WEST SUSSEX COUNTY COUNCIL CONSULTATION

TO:	Arun District Council FAO: Katie Sharp
FROM:	WSCC - Highway Authority
DATE:	7th June 2022
LOCATION:	Central Wetland Area Hampton Park Toddington Lane Littlehampton BN17 7PL
SUBJECT:	LU/369/21/RES Approval of reserved matters following outline consent LU/47/11/ (amended under LU/182/15/PL) for the main on-site infrastructure at Hampton Park and encompasses: 1) the Central Wetland Area, 2) the main spine road and crossing structures & 3) the SUDs features. Revised plans received.
DATE OF SITE VISIT:	n/a
RECOMMENDATION:	More information required
S106 CONTRIBUTION TOTAL:	SEE LATEST VERSION OF S106 AGREEMENT

This is the fourth WSCC County Highways (CHA) response to the above planning application for approval of reserved matters following outline consent LU/47/11/ (amended under LU/182/15/PL) for the main on-site infrastructure at Hampton Park and encompasses: 1) the Central Wetland Area, 2) the main spine road and crossing structures & 3) the SUDs features.

Typical Pile Reinforcement Section
Scale 1:20

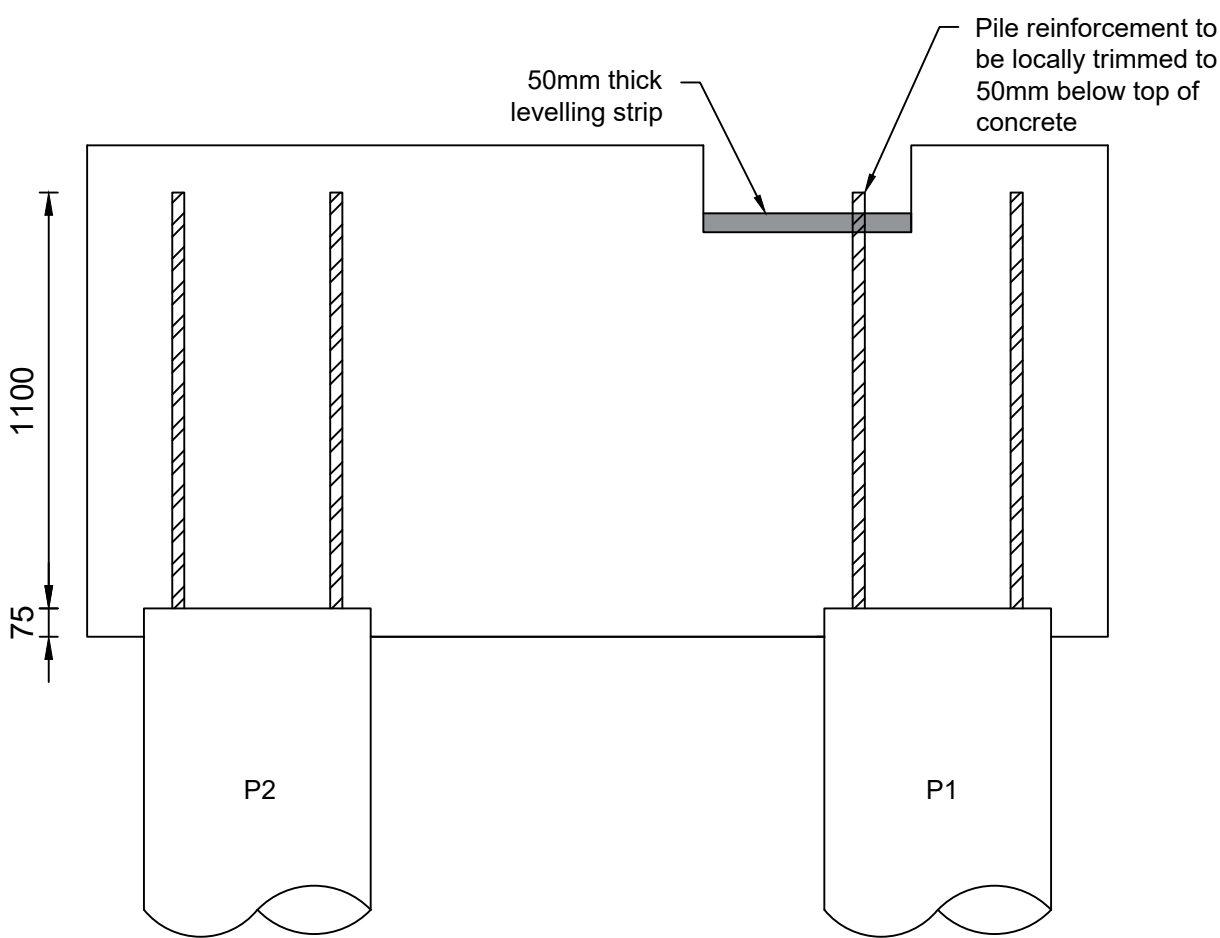
2. There's a drg. for the piles and piles caps (drg. 2231-001 & 002) that WSCC hasn't seen previously but wouldn't expect to see until the awaited Design and Check submission (which will also require approval) prior to construction.
